Russell Vale Colliery

UNDERGROUND EXPANSION PROJECT RESIDUAL MATTERS REPORT

**RUSSELL VALE COLLIERY
UNDERGROUND EXPANSION PROJECT**

**PREFERRED PROJECT
RESIDUAL MATTERS
REPORT**

Figure 4. New proposed position of Wongawilli LW7 as per the PPR.

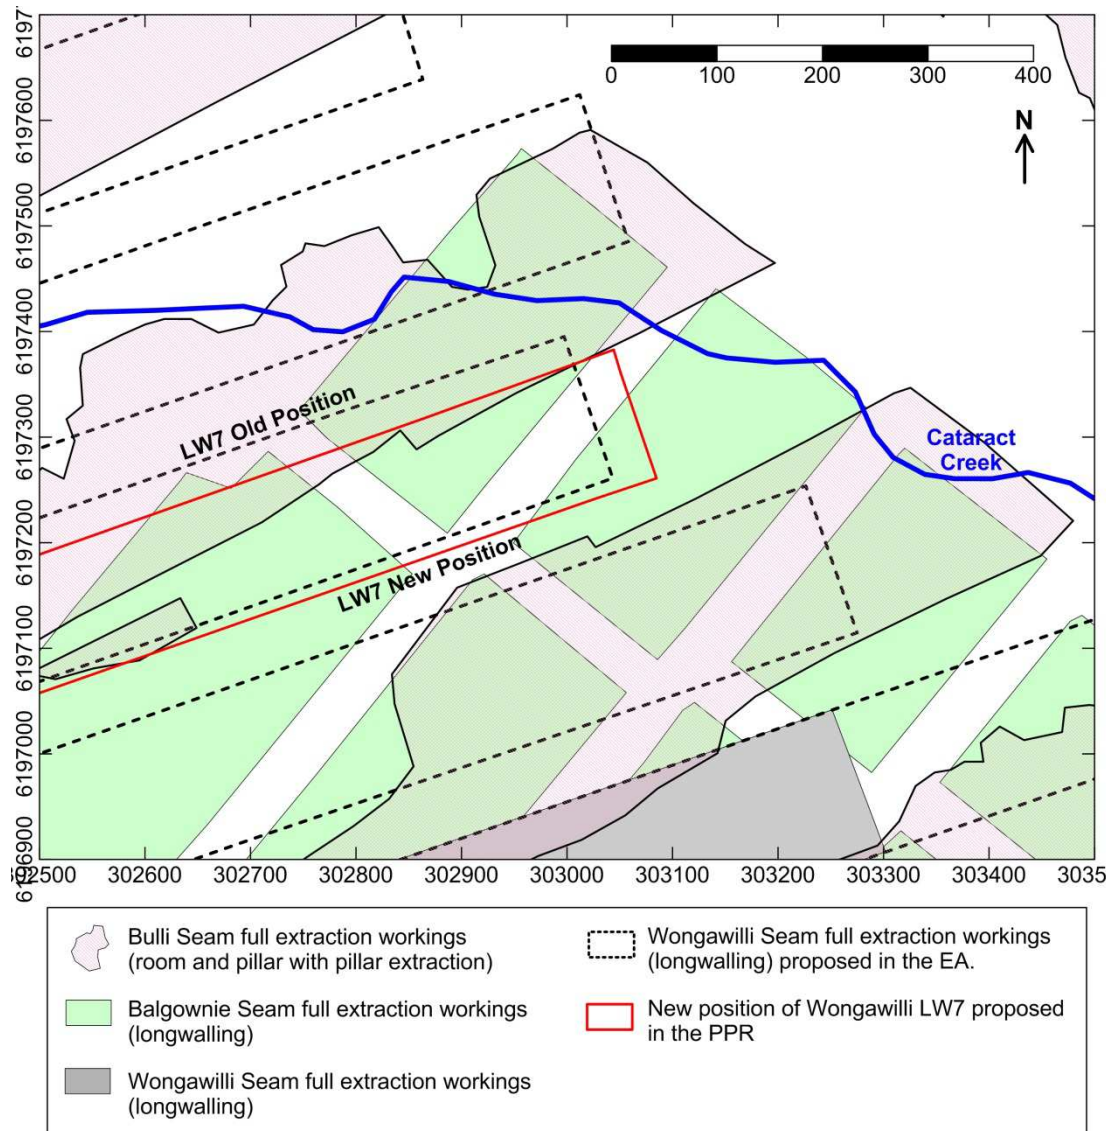
P&I noted that no scale is shown on the mine plan figure of the UEP PPR and also that it is not geo-referenced. P&I requires confirmation of the positioning of Cataract Creek with respect to LW7 of the PPR mine plan.

Figure 1 illustrates the mine plan for the UEP (to scale and with geo-referencing) to show the location of LW7 relative to Cataract Creek.
